Our ref: DOC22/1017183
Your ref: SSD-9679

Hills of Gold Wind Farm – Amended Project – November 2022

Hills of Gold Wind Farm – Amended Project

Hills of Gold Wind Farm – Residual matters and Amended Project

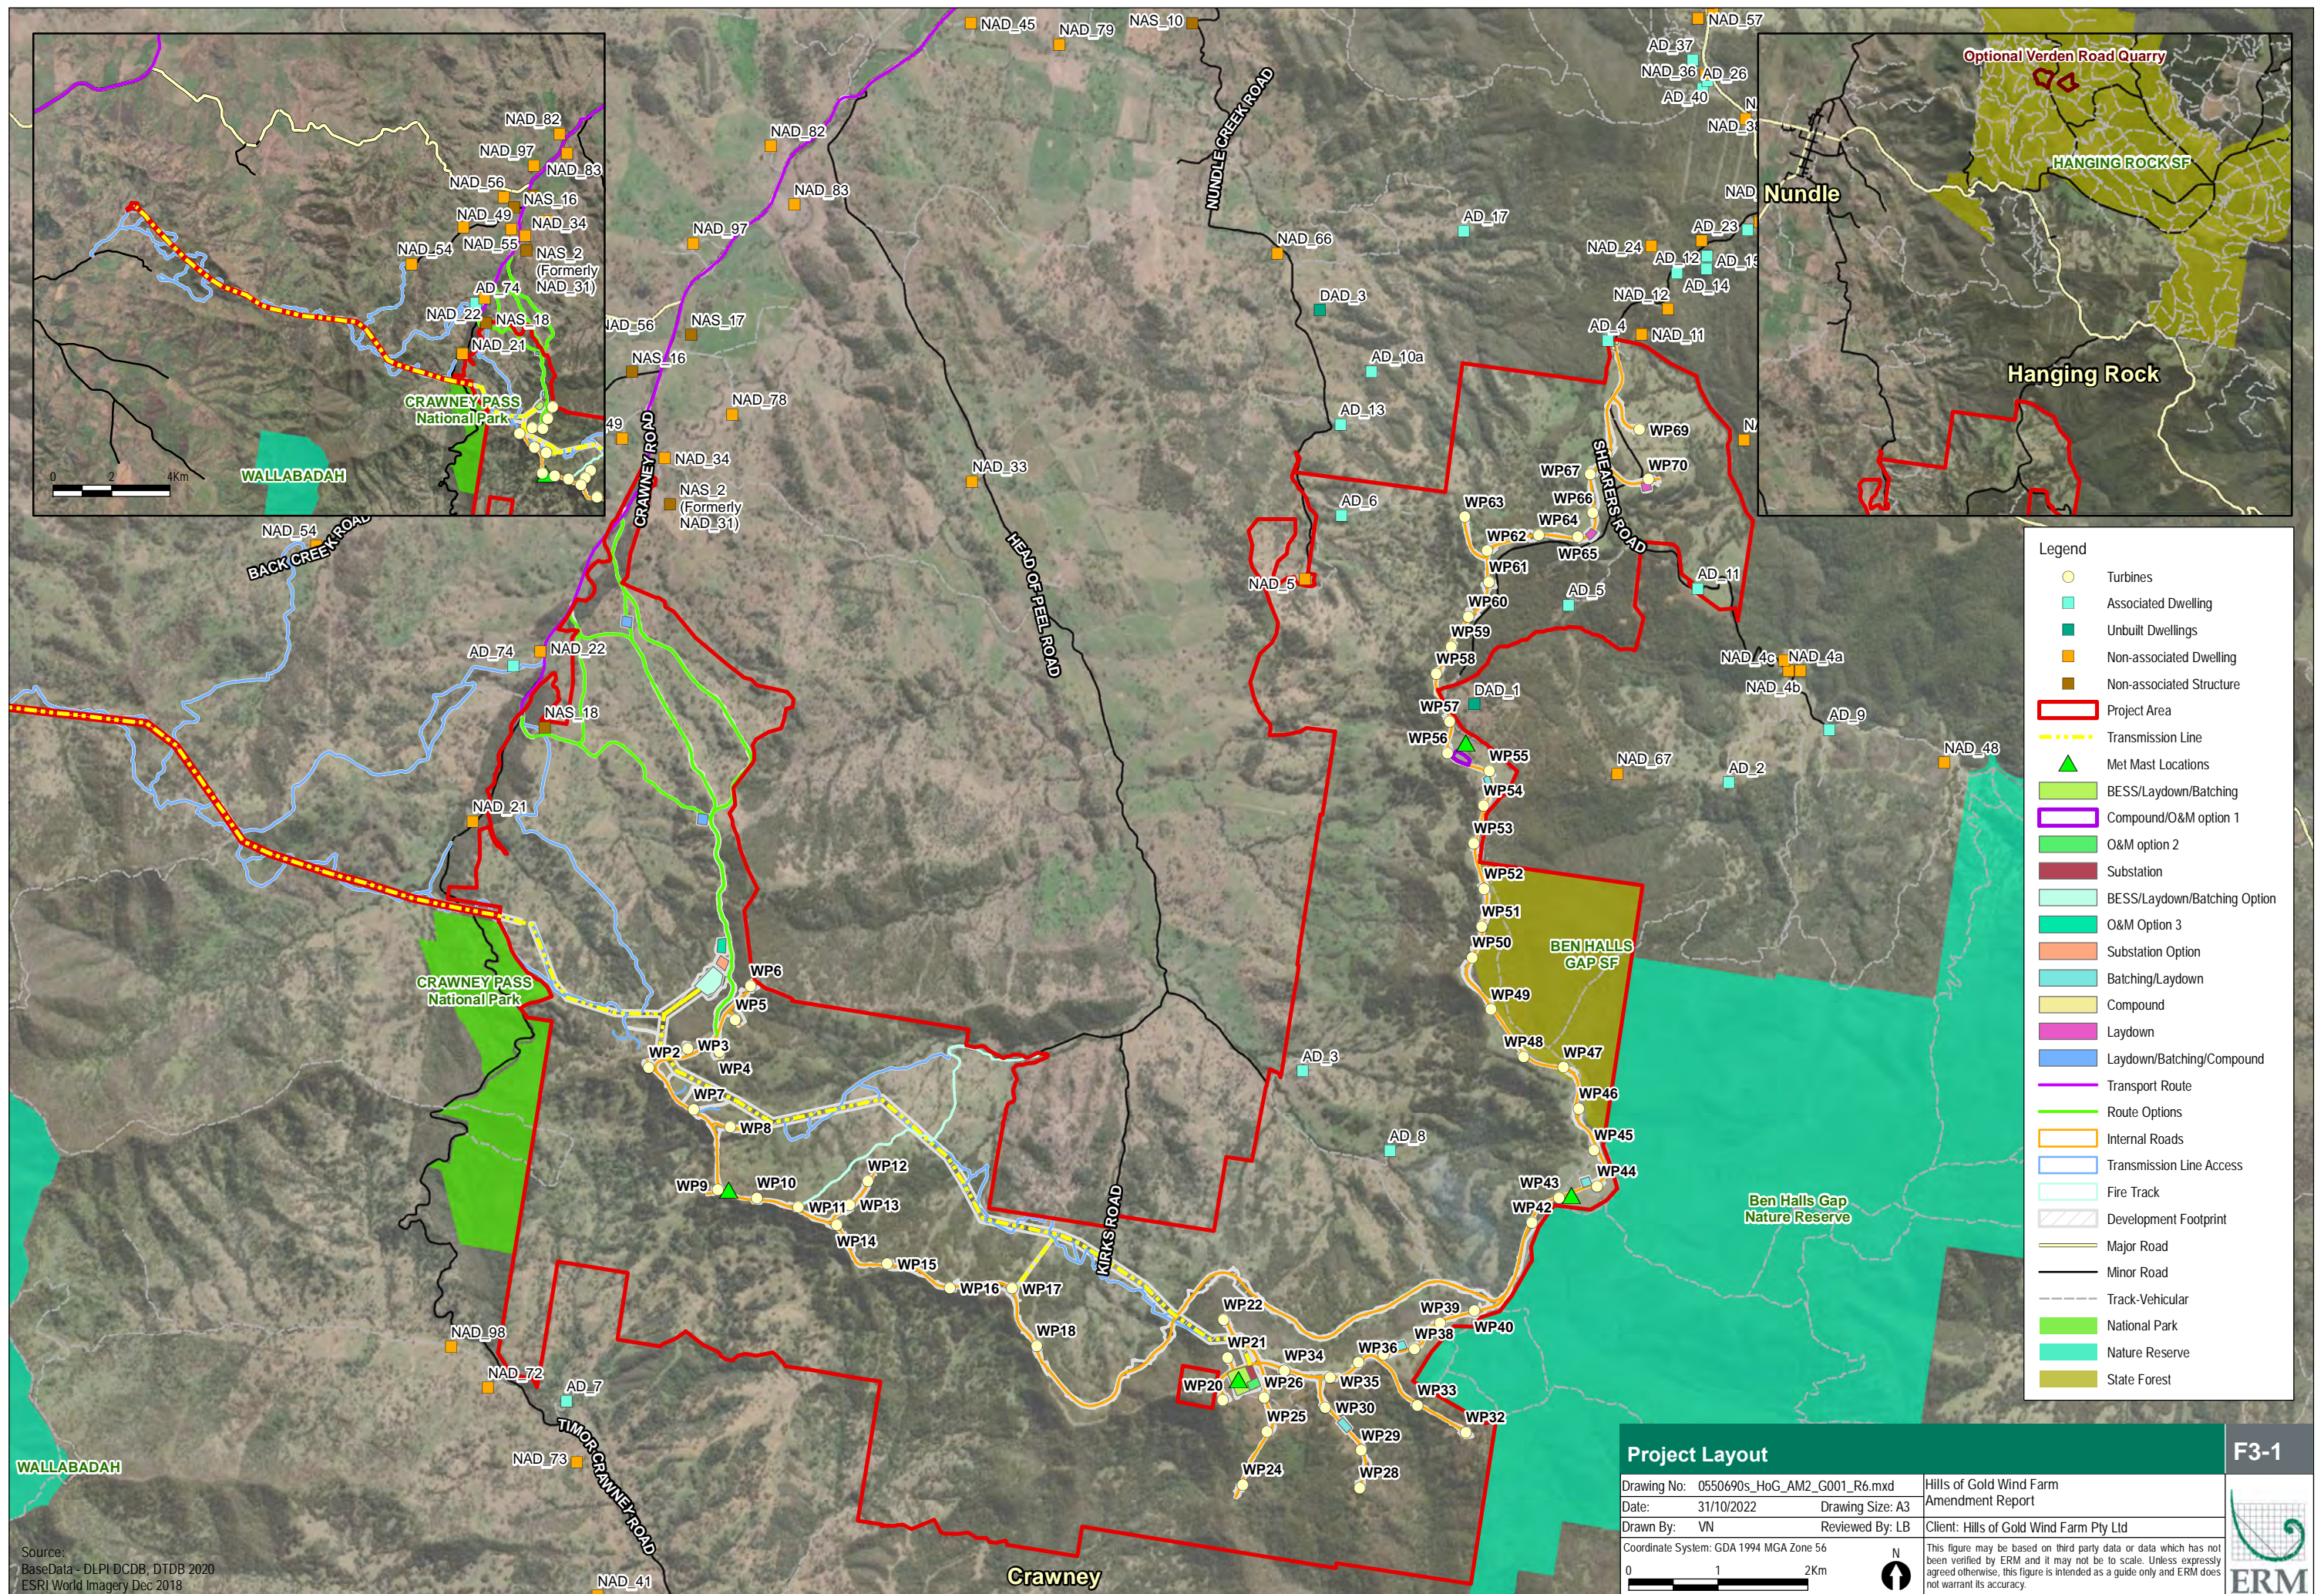
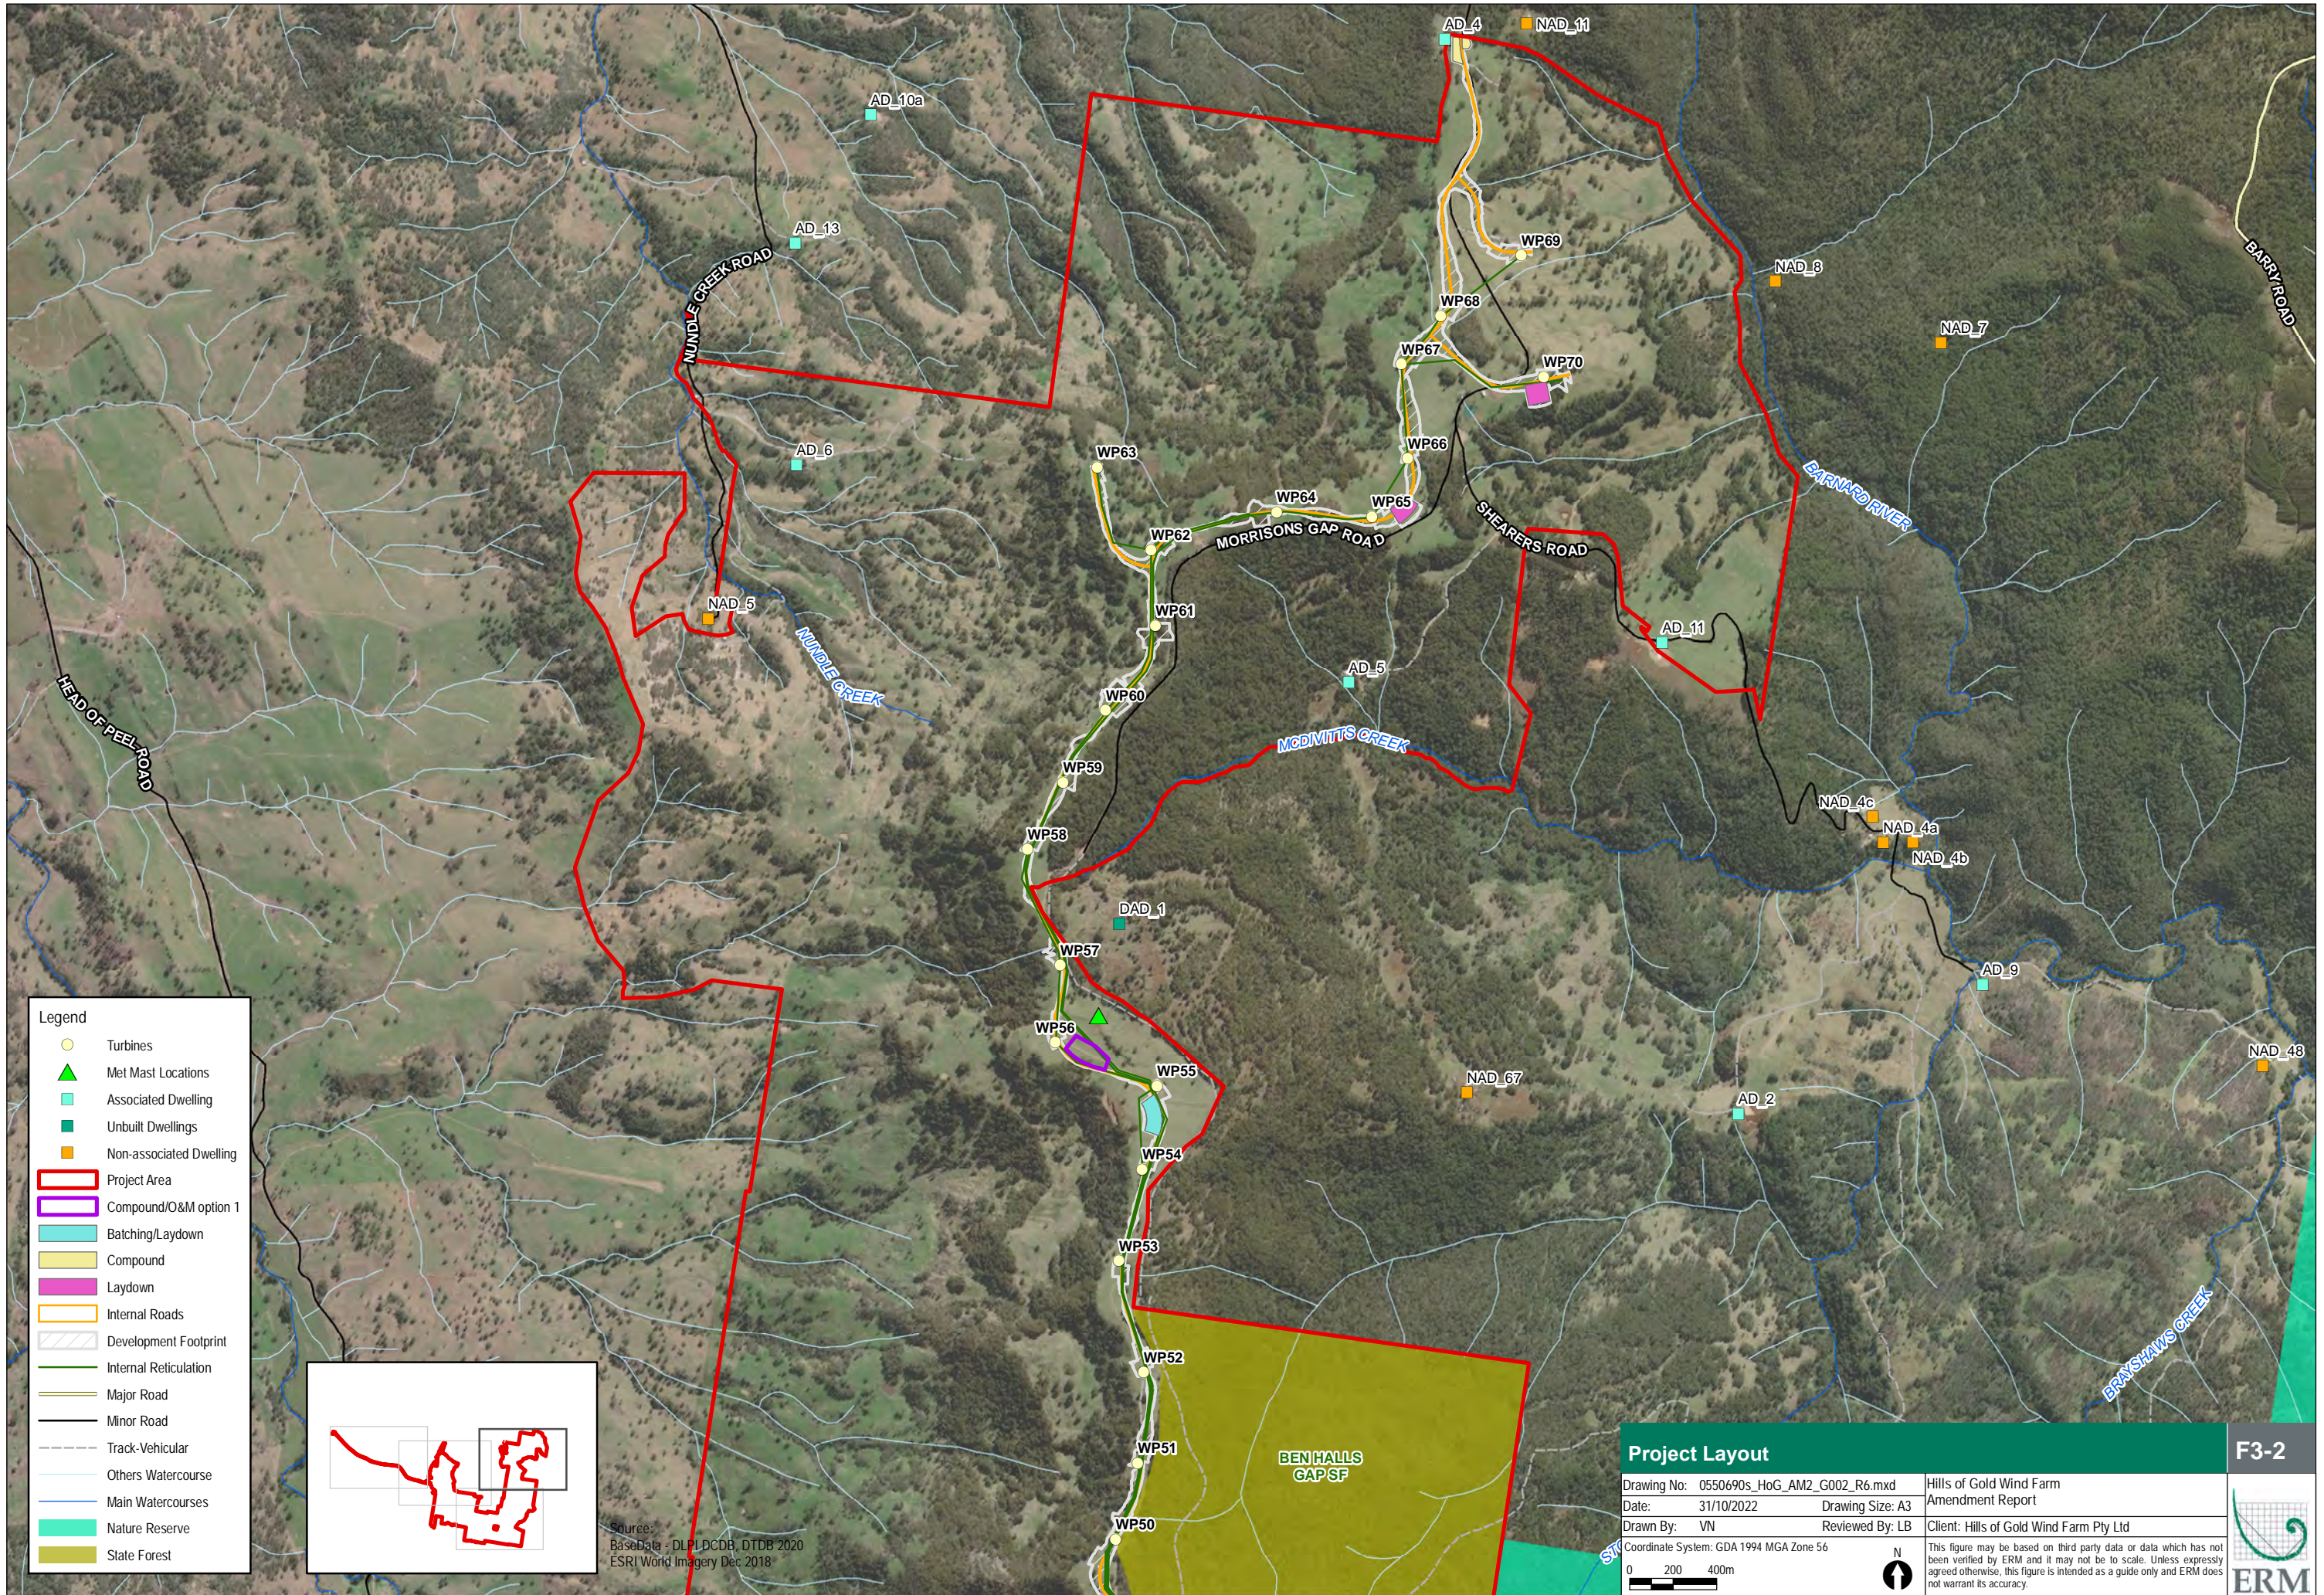
There are several turbines that BCS regards as potentiation candidates for deletion from the project. For example, turbines WP24 and WP28 are placed in PCT 1194, a Threatened Ecological Community (TEC). It is stated in Table 54 that further avoidance of biodiversity impacts is not possible for these turbines, due to the turbines being located within a highly vegetated area. The deletion of these turbines from the project will achieve further avoidance of a TEC as well as reduce the potential of blade strike for microbats.

- 2.2 Where moderate risk turbines are unrelocatable and proposed to be retained detailed justification is required. In the absence of detailed justification, the relative impact of each turbine should be considered and turbines resulting in the highest biodiversity impact should be deleted.
